Protest
Insufficient

5. [Petition No. 2013-047](#) (Council District 2 – Mitchell) by Brookline Residential, LLC for a change in zoning for approximately 26.68 acres located on the west side of Interstate 77 near the intersection of Reames Road and Lakeview Drive from MX-1 to UR-2(CD).

This petition is found to be inconsistent with the *Northlake Area Plan*; however, to be reasonable and in the public interest, by a 4-1 vote of the Zoning Committee. The Committee voted 4-1 to recommend **APPROVAL** of this petition with the following modifications:

PRELIMINARY SITE PLAN

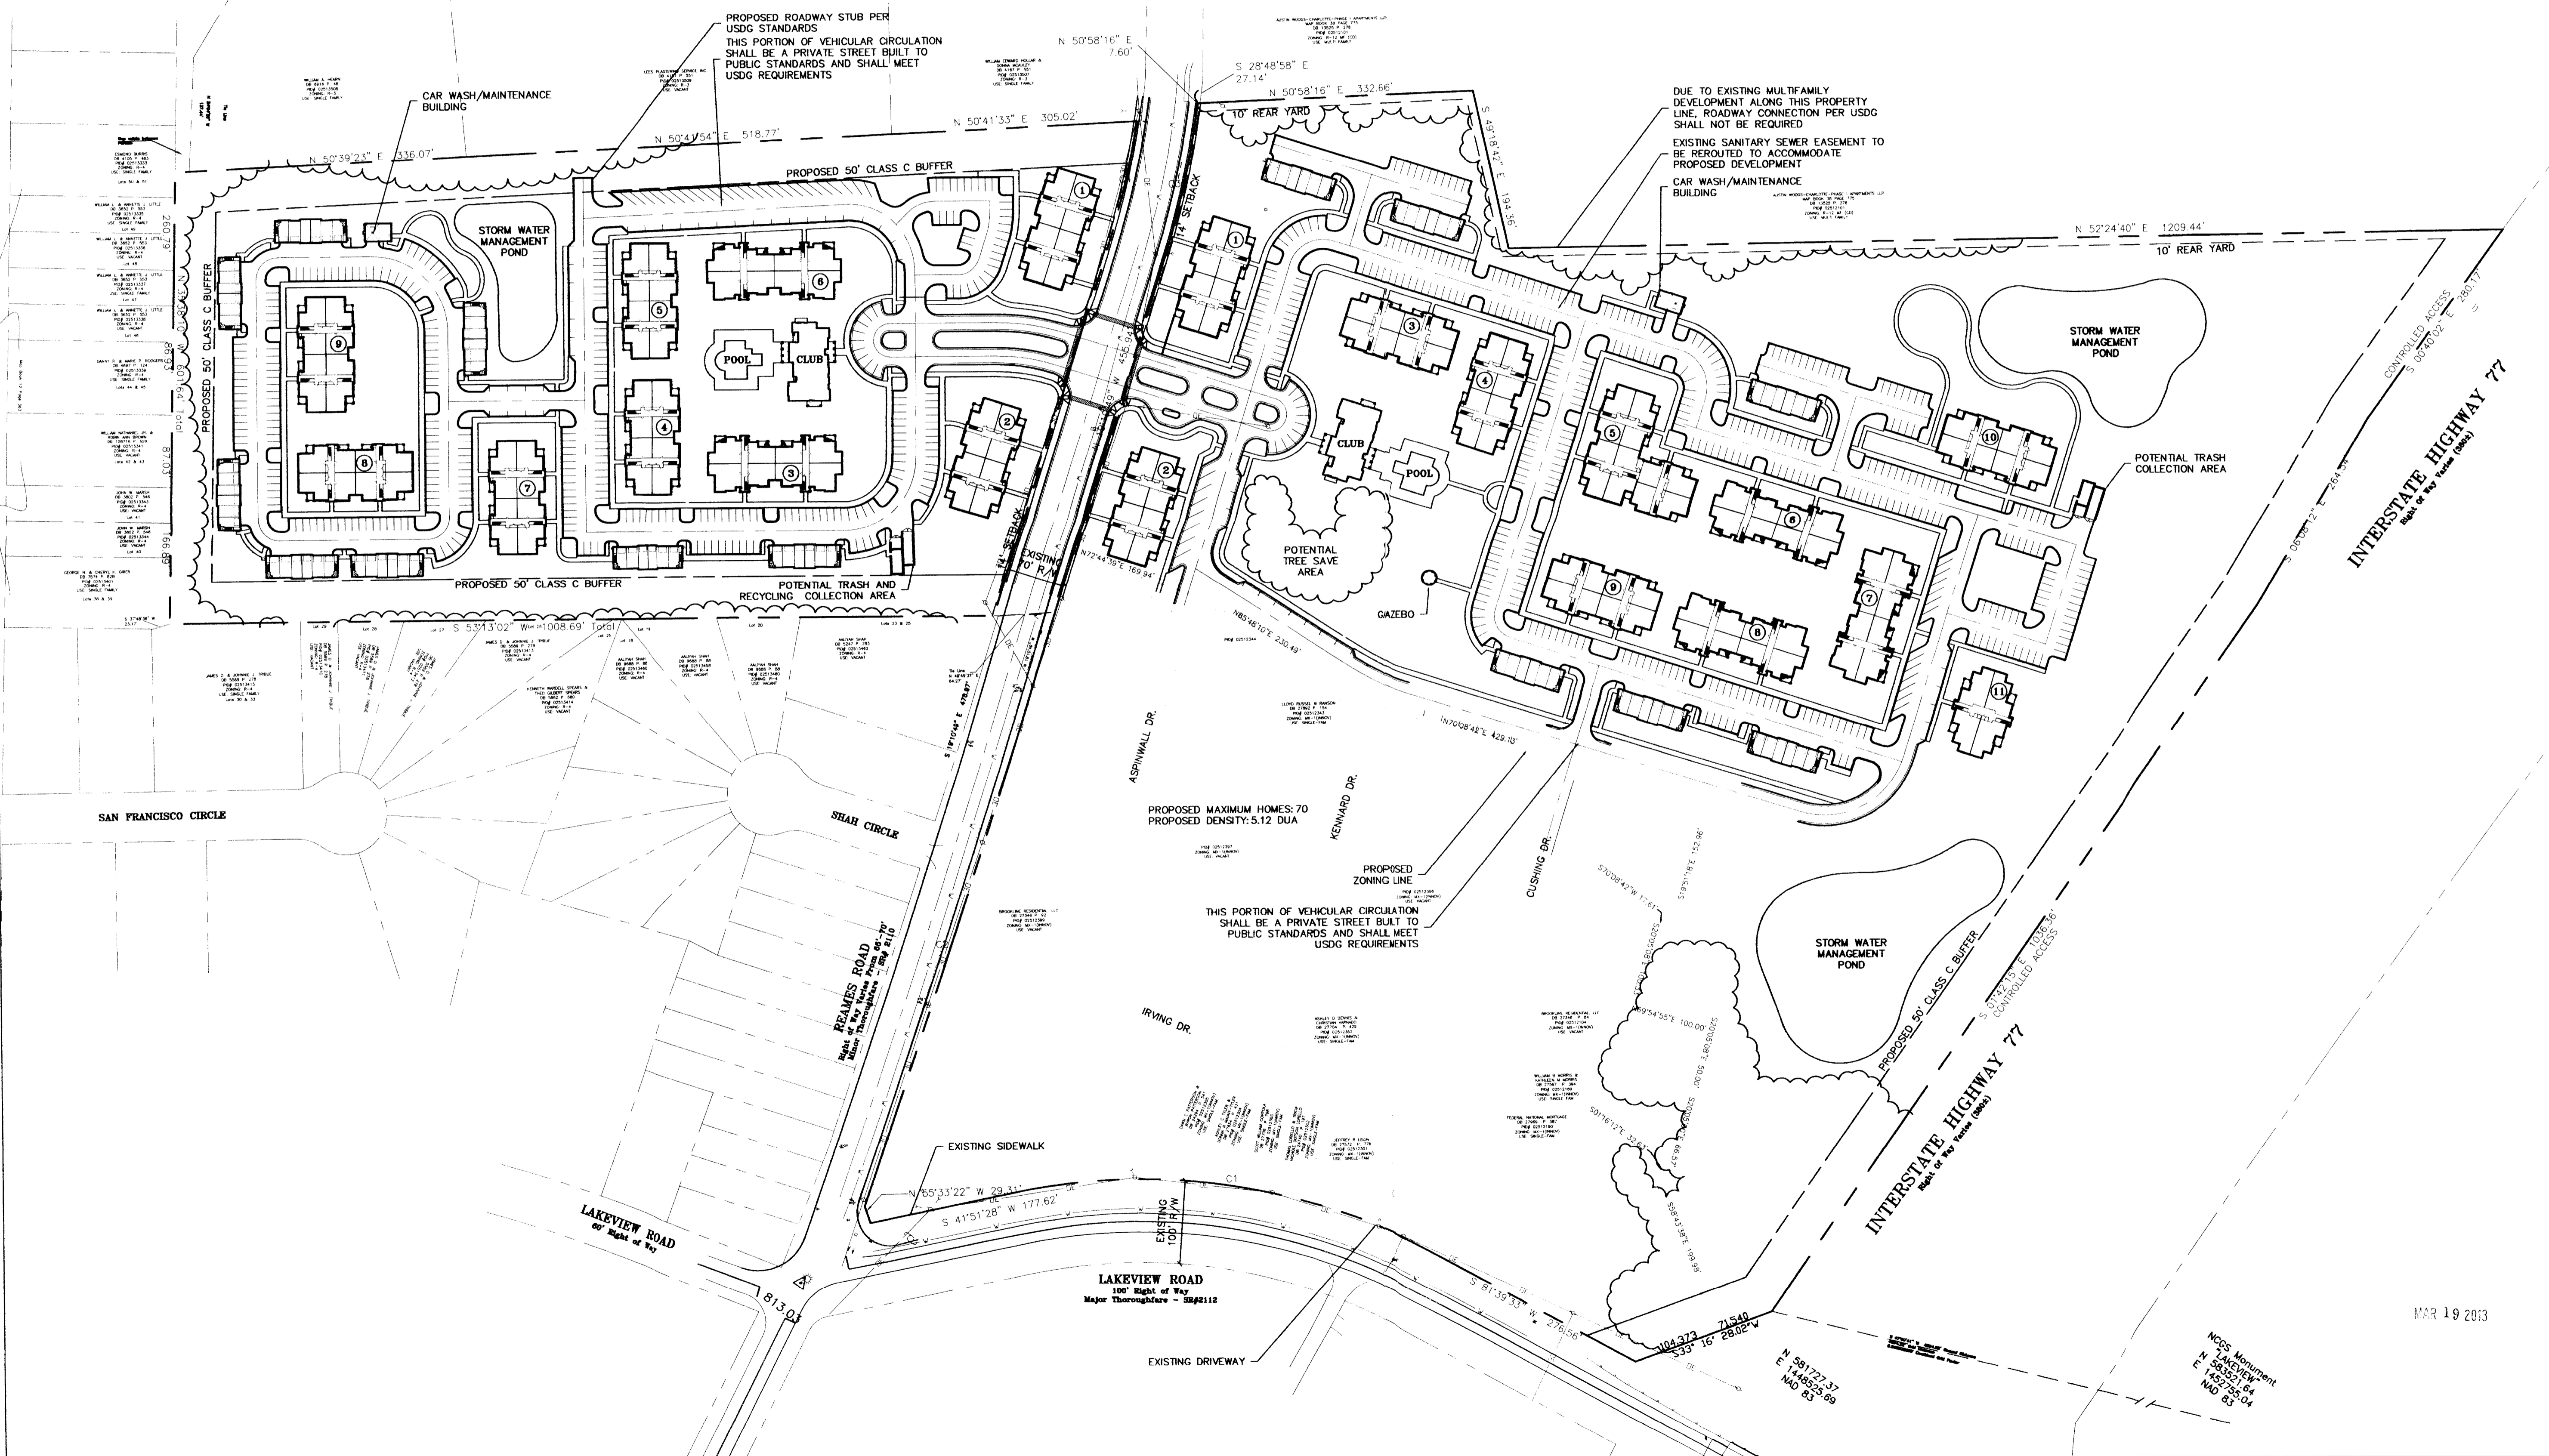
15. On Sheet RZ-2, extended the internal sidewalk along the private street between buildings 4 and 5 out to the internal sidewalk along Boylston Drive.

16. On Sheet RZ-2, extended the internal sidewalk along the private street between buildings 7 and 11 out to the internal sidewalk along Boylston Drive.
